28 July 2016

File No: 2016/401214  
Our Ref: R/2015/18/A

**RE: LEES 1 Science Research and Teaching Facility (SSD 7054) and F23 Administration Building (SSD 7055) – The University of Sydney**

<table><tr><td>SCALE</td><td>CHECKED</td><td>DATE</td></tr><tr><td></td><td>DA 20</td><td>A</td></tr></table>

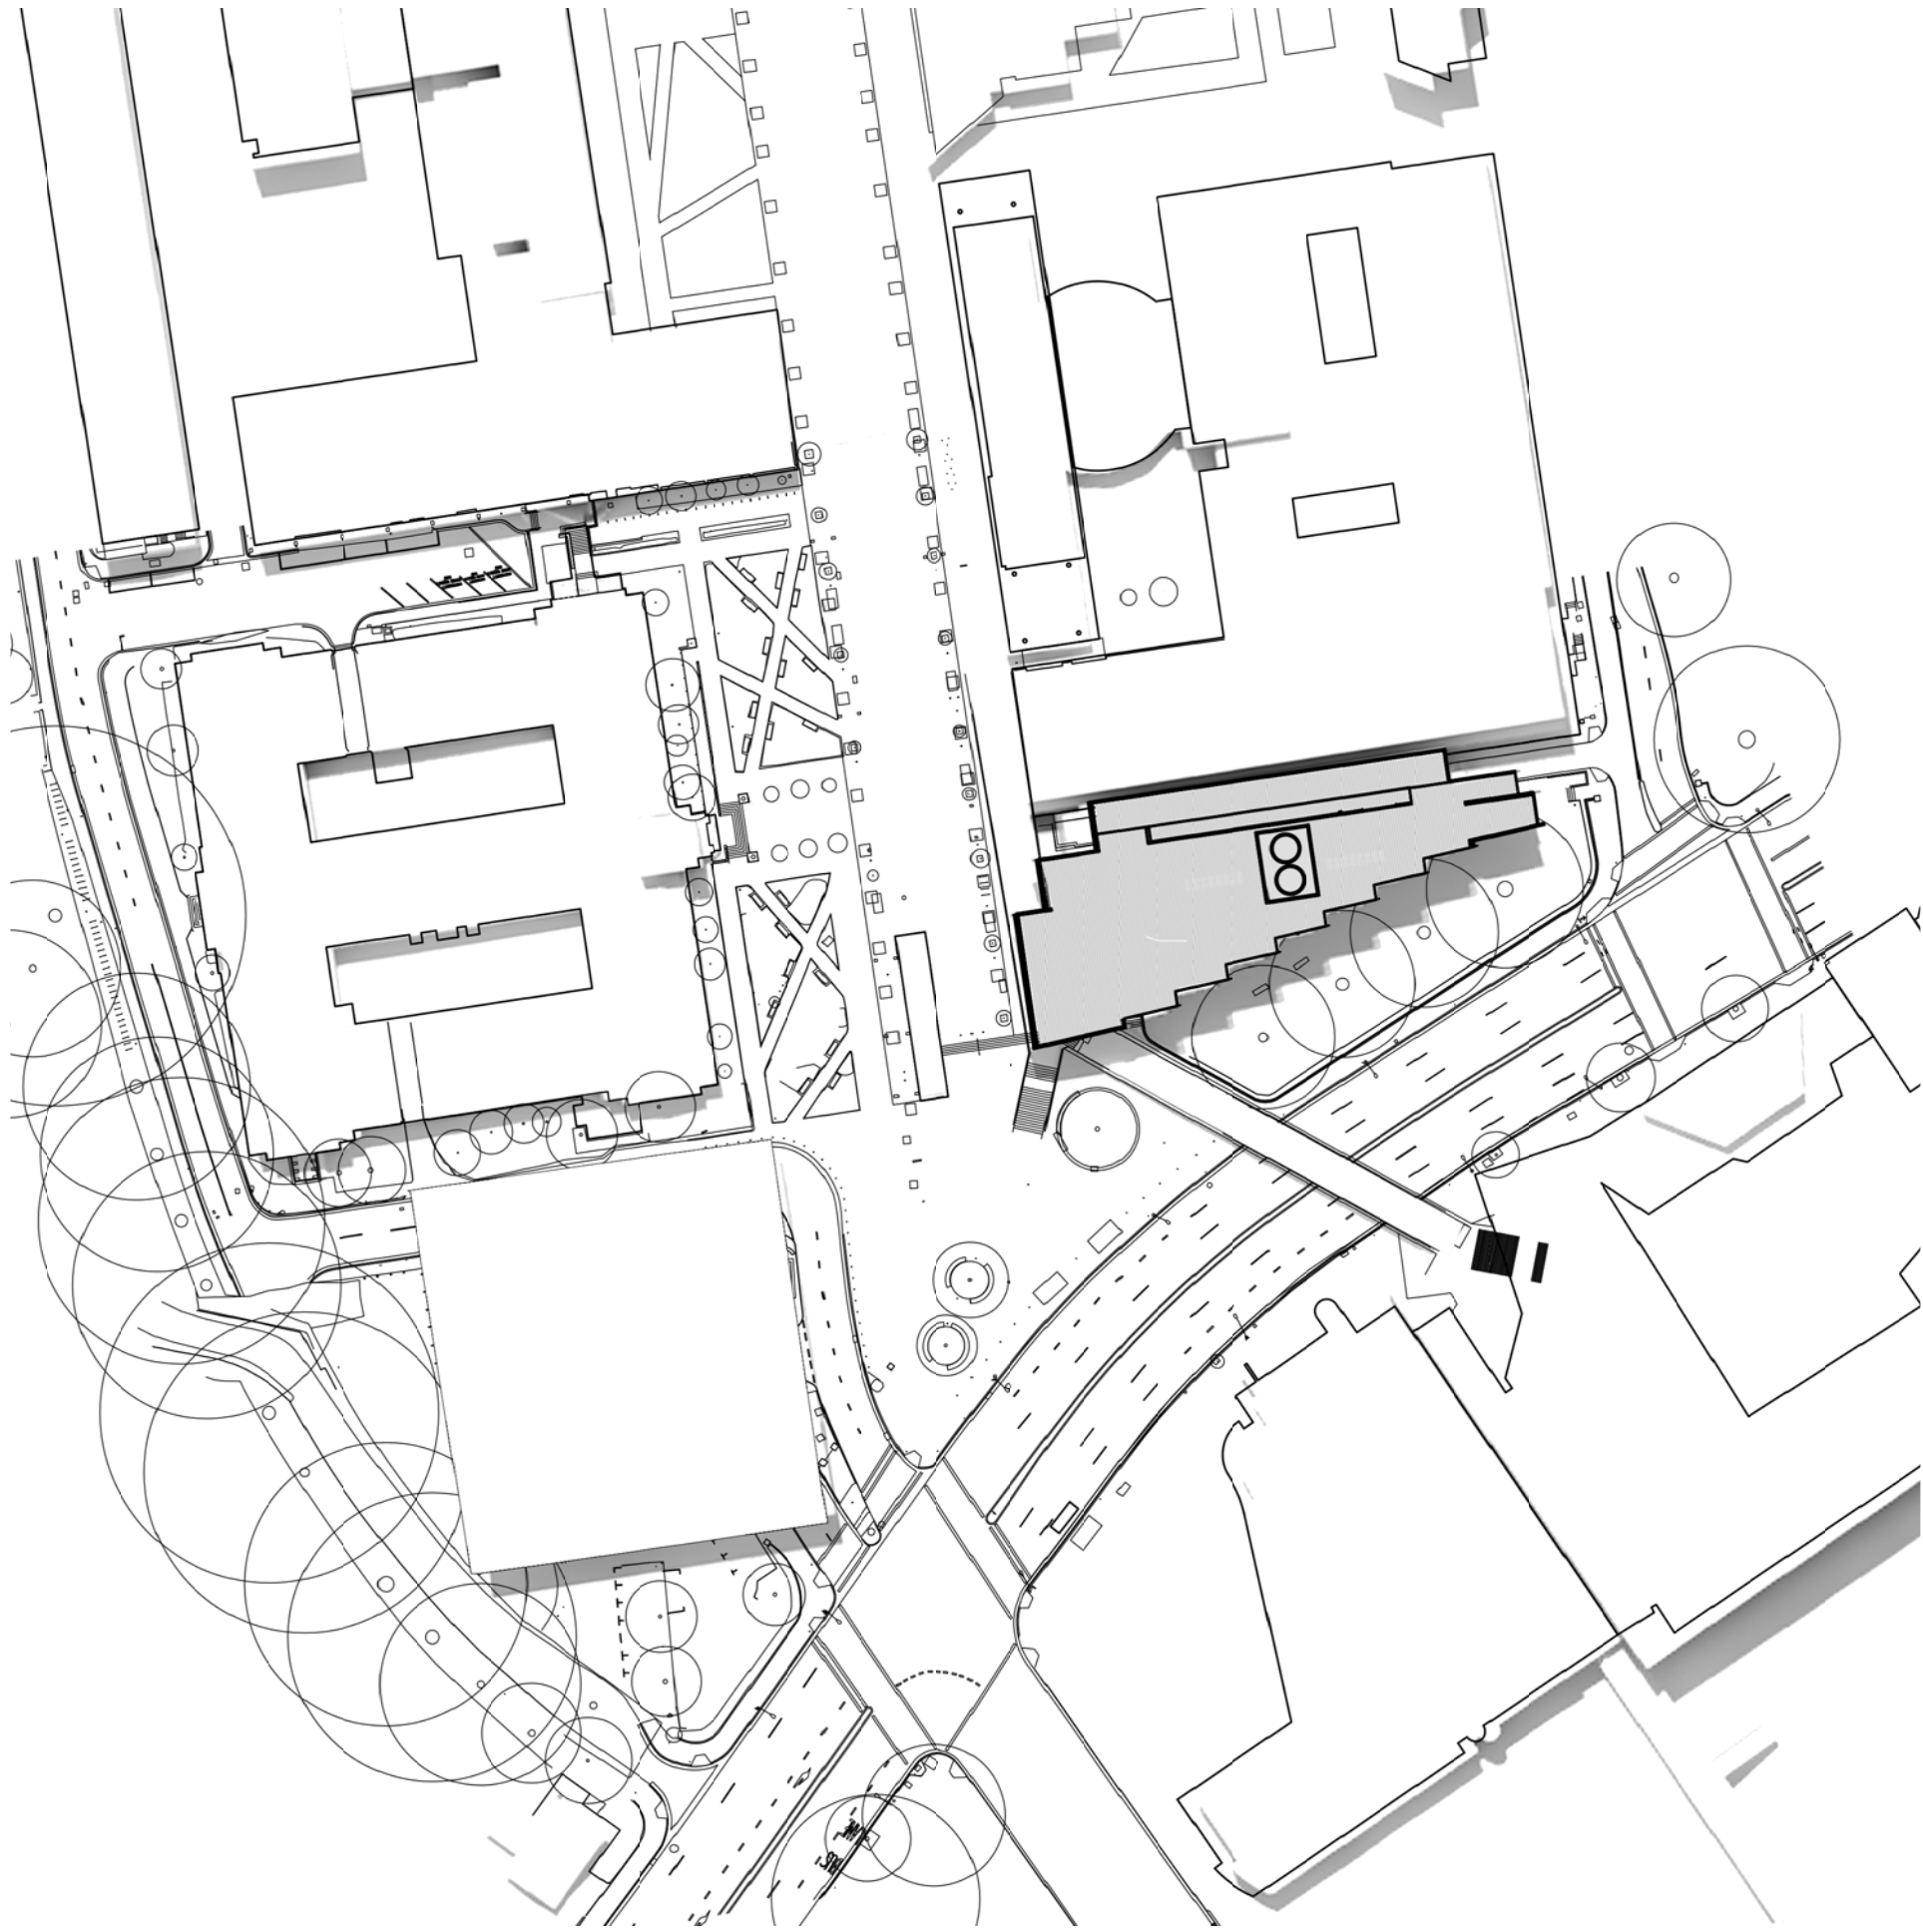
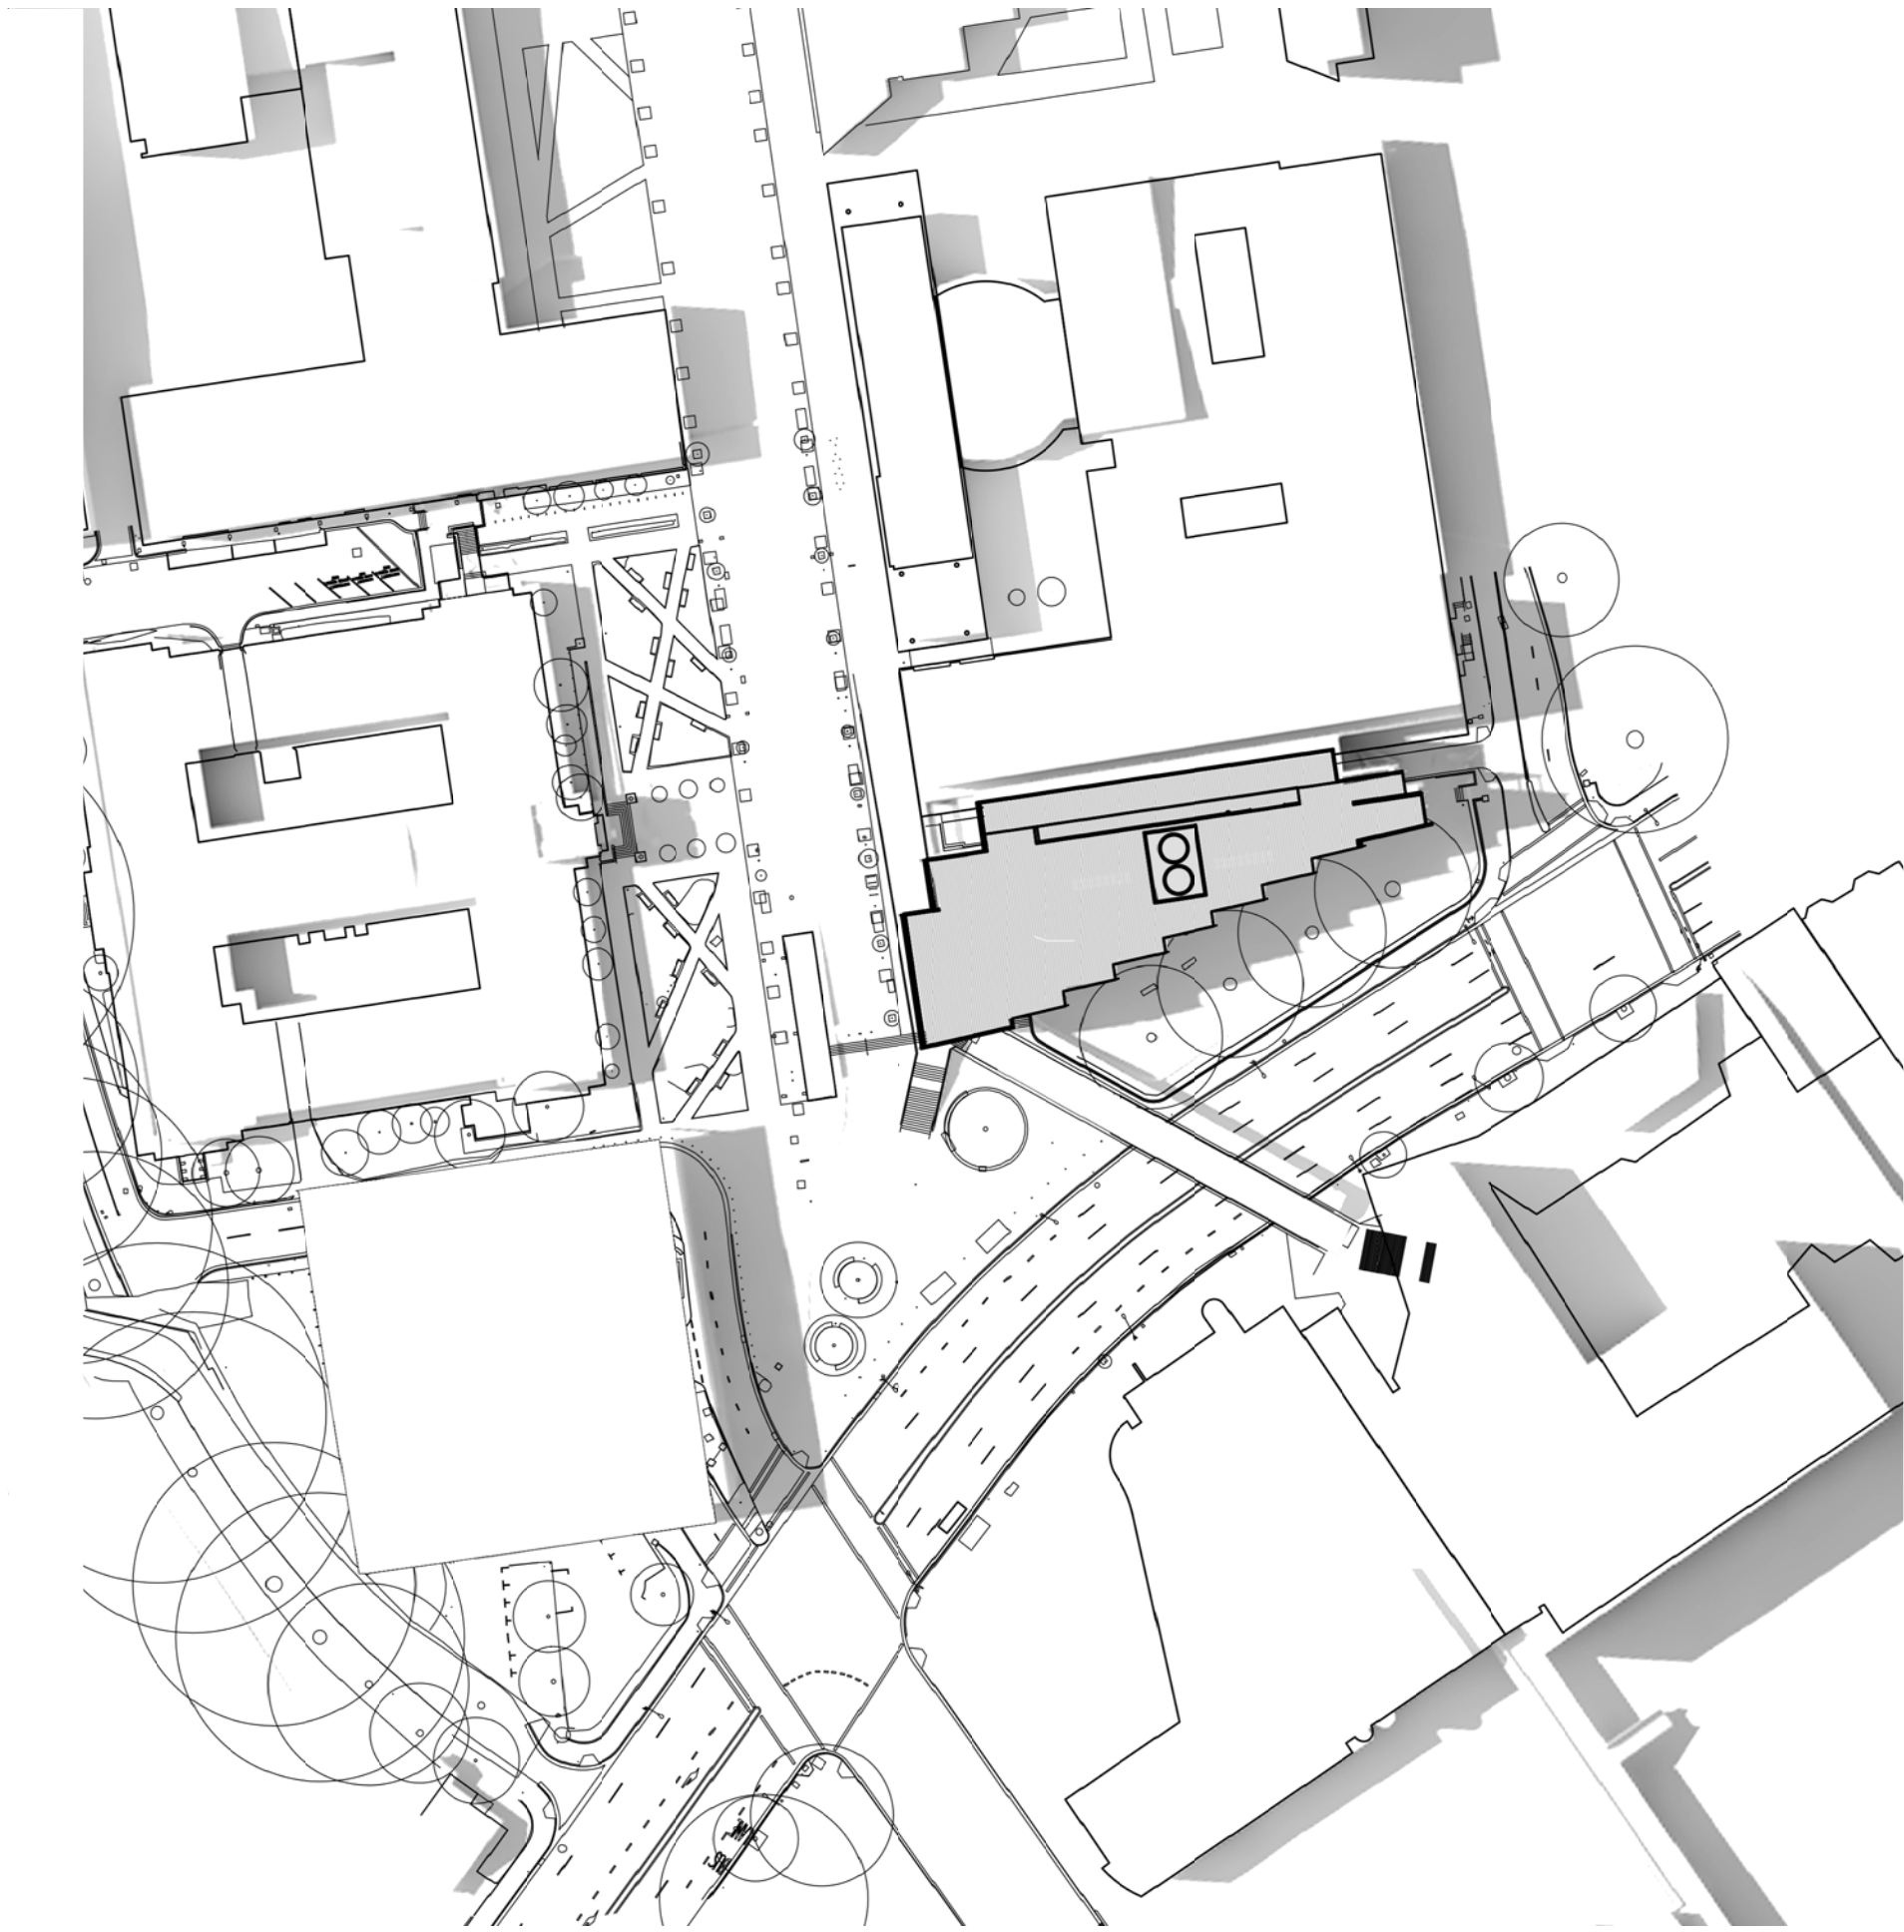
Detailed diagrams are required to differentiate the existing shadow from that of the shadows cast by the proposal. The diagrams illustrate significant overshadowing of the existing (retained) Fig trees along City Road between midday and 3pm. This is likely to result in adverse impacts upon tree health and longevity.

Shadow impacts upon the Sydney University Building on the southern side of City Road are also indicated in the drawings. The extent of this overshadowing is unclear.
